East Anglia TWO Offshore Wind Farm

Appendix A15b to the Natural England Deadline 7 Submission

**Natural England's Response to Offshore Ornithology Compensation and
Derogation Documents [REP6-044, REP6-045 and REP6-046]**

Planning Inspectorate Reference: EN010078

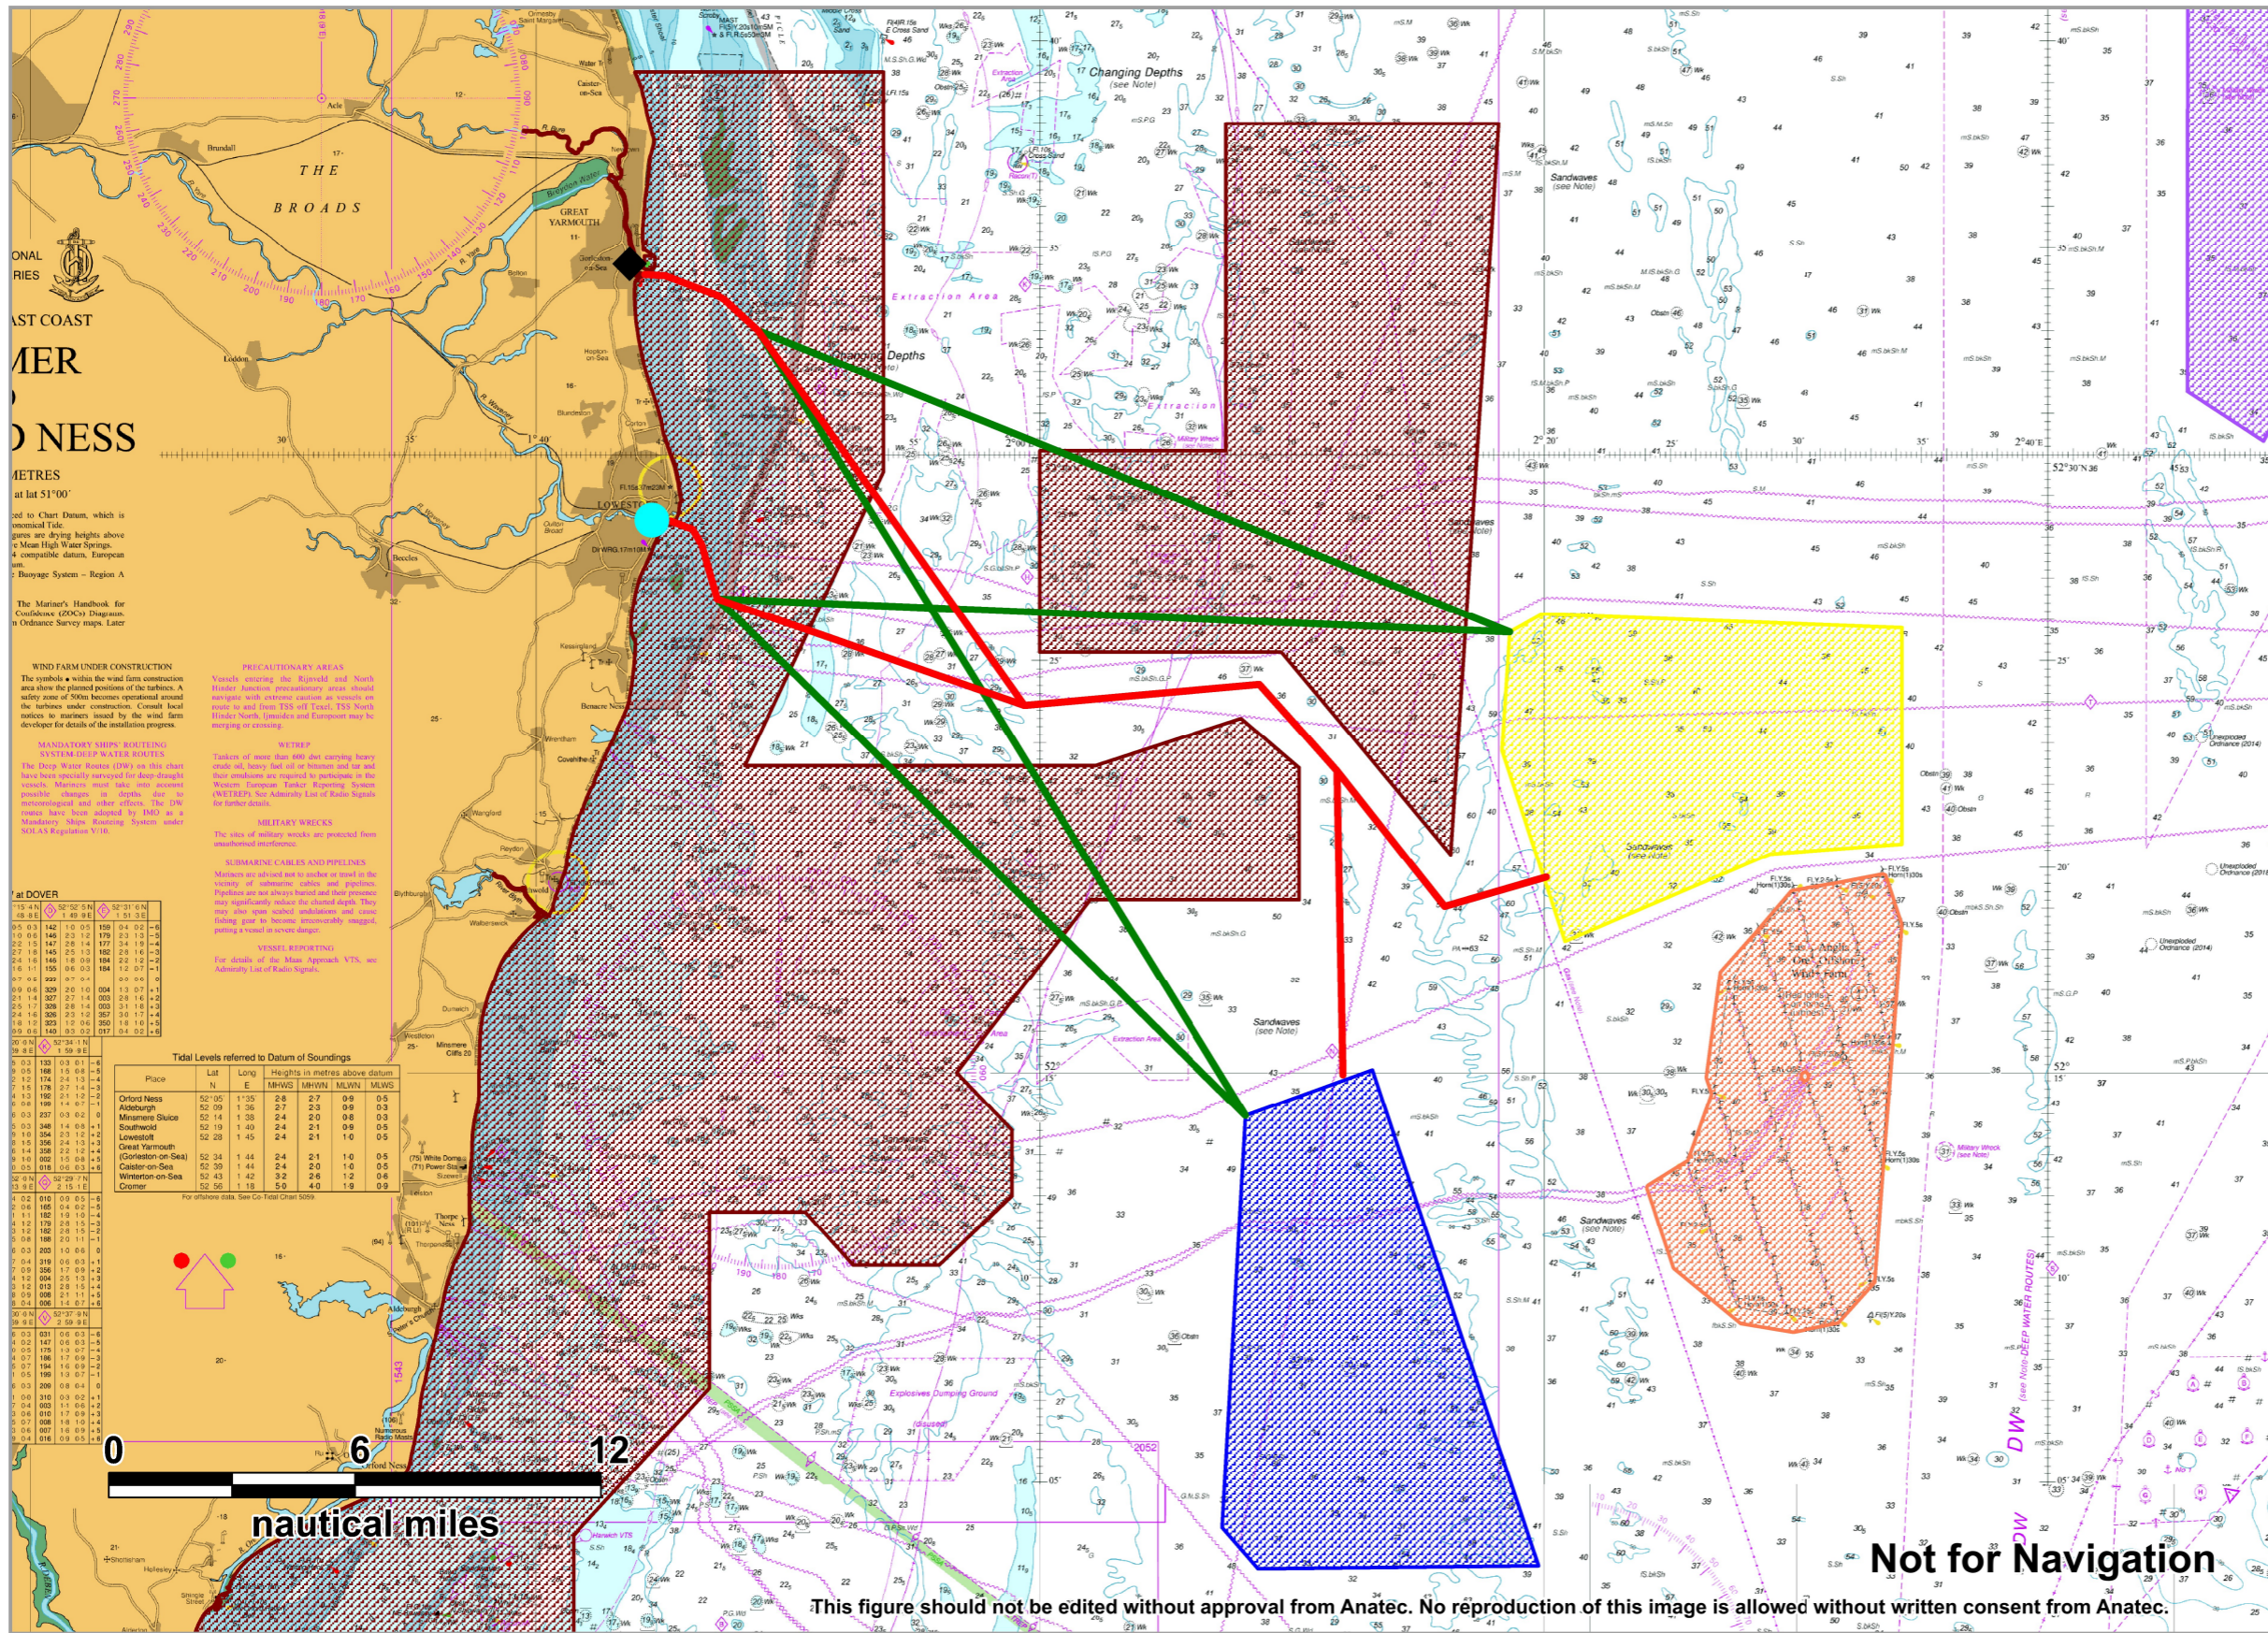
41. Whilst we agree with the Applicant that this measure would not address the current levels of displacement within the SPA, we disagree that management of existing and planned vessel traffic in association with SPRs interests in the area would represent a reduction. This is because EA1N and EA2 have committed to a best practice protocol to minimise vessel disturbance [REP3-074]. A similar protocol is in place for East Anglia ONE. This includes:

- Avoid and minimise vessel traffic, where possible, during the most sensitive time period for red-throated diver between November and March 1st inclusive.
- Restrict vessel movements where possible to existing navigation routes (where the densities of divers are typically relatively low).
- Where it is necessary to go outside of established navigational routes, avoid rafting birds either on route to the windfarm sites from port and/or within the windfarm sites (dependent on location) and where possible avoid disturbance to areas with consistently high diver density.

42. Therefore, Natural England's advice is this proposal does not provide any means of reducing the displacement effects from the presence of the turbines.
